**KIRKLEES COUNCIL
TOWN AND COUNTRY PLANNING ACT 1990
HIGHWAYS DEVELOPMENT MANAGEMENT**

PLANNING REF 2017/62/91093/W0/CM
CATEGORY Minor

PROPOSAL ERECTION OF 2 SEMI DETACHED
DWELLINGS WITH ASSOCIATED
EXTERNAL WORKS(WITHIN A
CONSERVATION AREA)

LOCATION OLD BANK WORKS
SLAITHWAITE
HUDDERSFIELD
HD7 5AR

PROPOSED SITE PLAN (1:200)

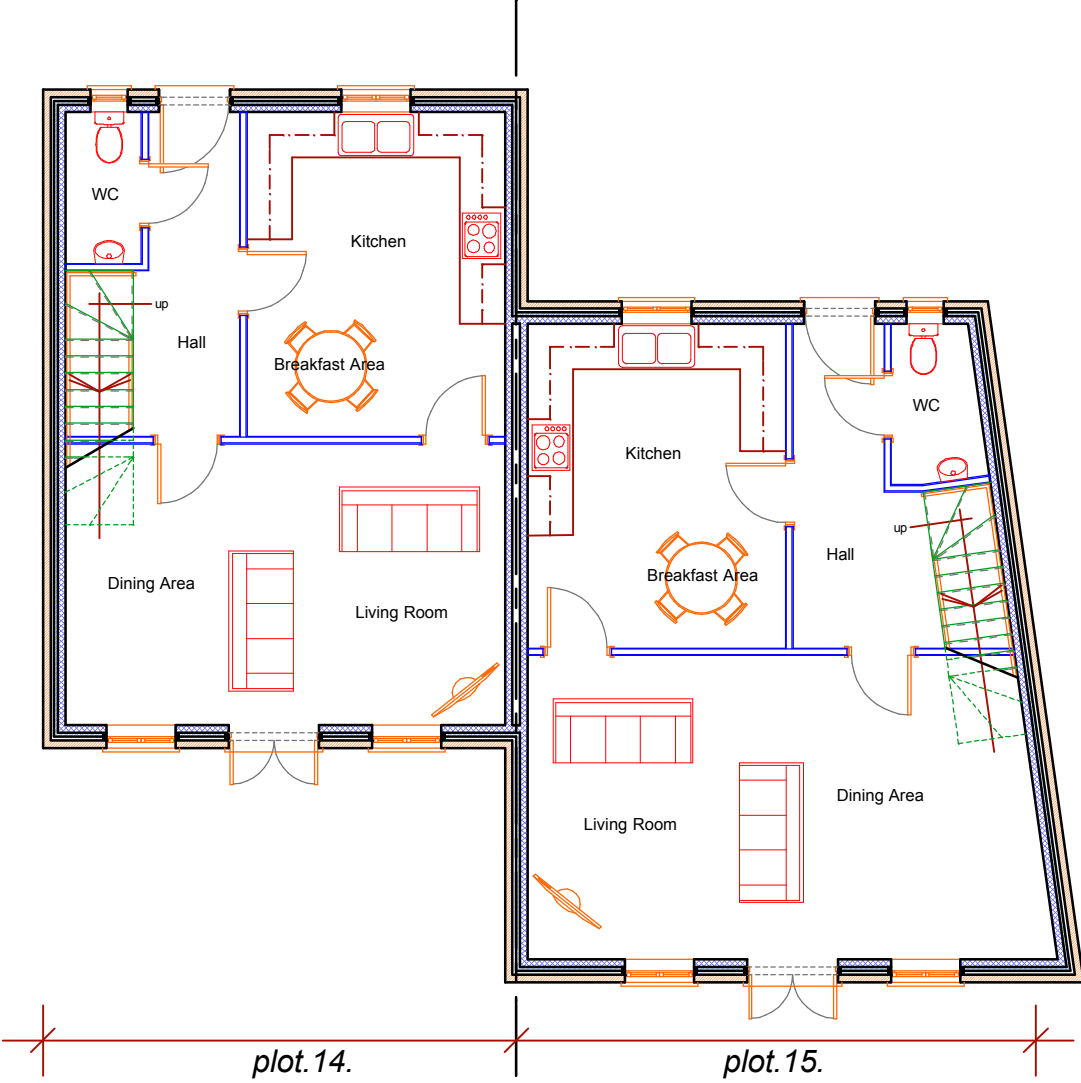
Under normal circumstances, the three-bedroomed dwellings would require two parking spaces per property, plus a space for visitors. The width of the adopted access road between Old Bank and Nabbs Lane is also inadequate to allow vehicles to turn properly into the proposed parking spaces.

Notwithstanding the details within the submitted Design & Access Statement, which are not approved, details of the surfacing material for the three parking spaces shall be submitted to and approved in writing by the Local Planning Authority before development commences. The parking areas shall thereafter be surfaced and drained in accordance with the approved details before either of the two semi-detached dwellings are occupied and thereafter retained.

Before development commences, the sightlines of 2m x site frontage shall be cleared of all

Reason: The use of tarmac with concrete pin edging within the historic core of the Slaithwaite Conservation Area would severely detract from the designated heritage asset and as such, an alternative surfacing material shall be used in the interests of visual amenity and so as to preserve the historic character of the Slaithwaite Conservation Area to accord with Policies BE1, BE2 and BE5 of the Unitary Development Plan as well as national policy in PPS5.

obstructions to visibility exceeding 1m in height and these shall be retained free of any such obstruction.
